Application No: AB/114/20/PD
Site Address: Riverside House 2 Fitzalan Road Arundel BN18 9JS
Description of works: Notification for Prior Approval under Schedule 2 Part 1 Class AA for a additional 2 storeys on existing dwelling house.

Thank you for your internet representation made on 26th November 2020 which has been recorded as an objection with the comments as follows:

Drawing Title:
PROPOSED ELEVATIONS

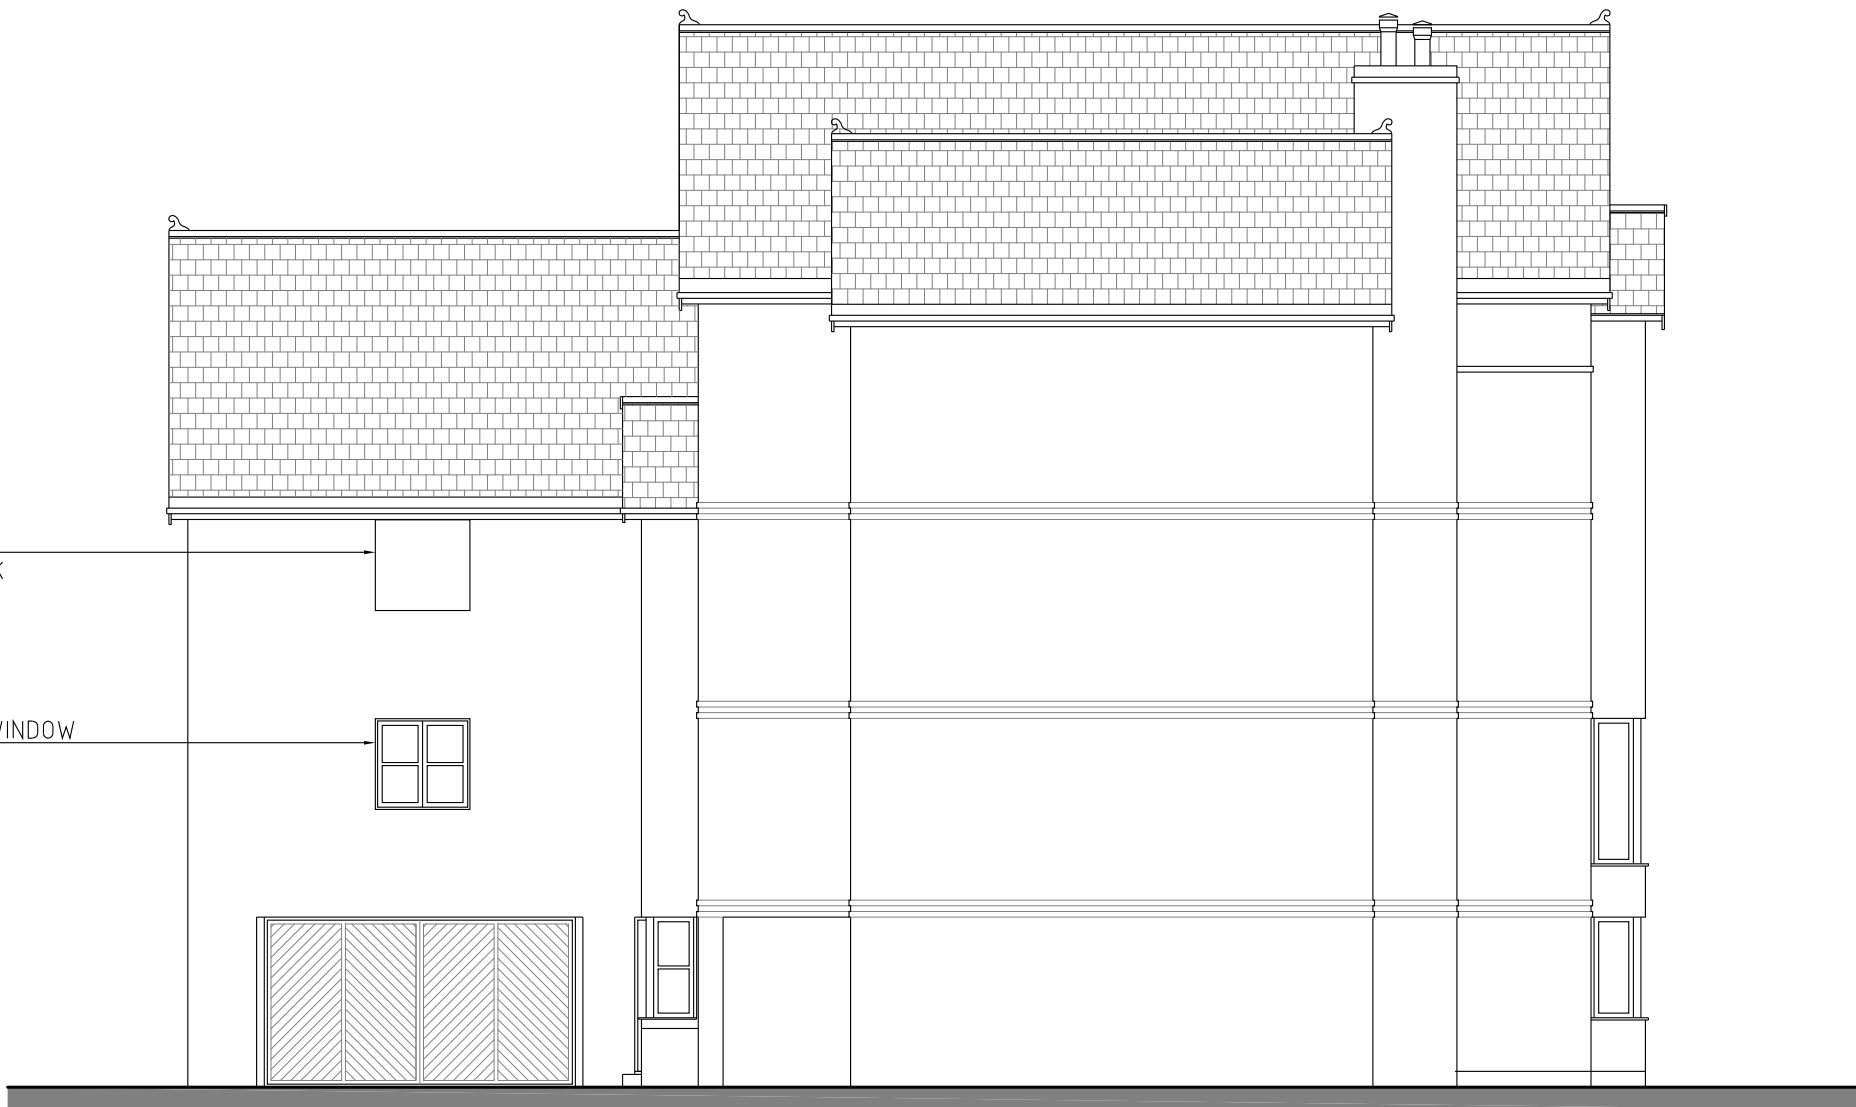
The proposed two storey extension by reason of its site coverage, bulk, height, proximity to the site boundaries and location close to the Arundel Conservation Area would result in a prominent and obtrusive dwelling which would adversely affect the visual amenities and the character of the area and would not preserve or enhance the setting of the Conservation Area. It would therefore be contrary to policies AREA2, GEN7 and DEV19 of the Arun District Local Plan and the National Planning Policy Framework.
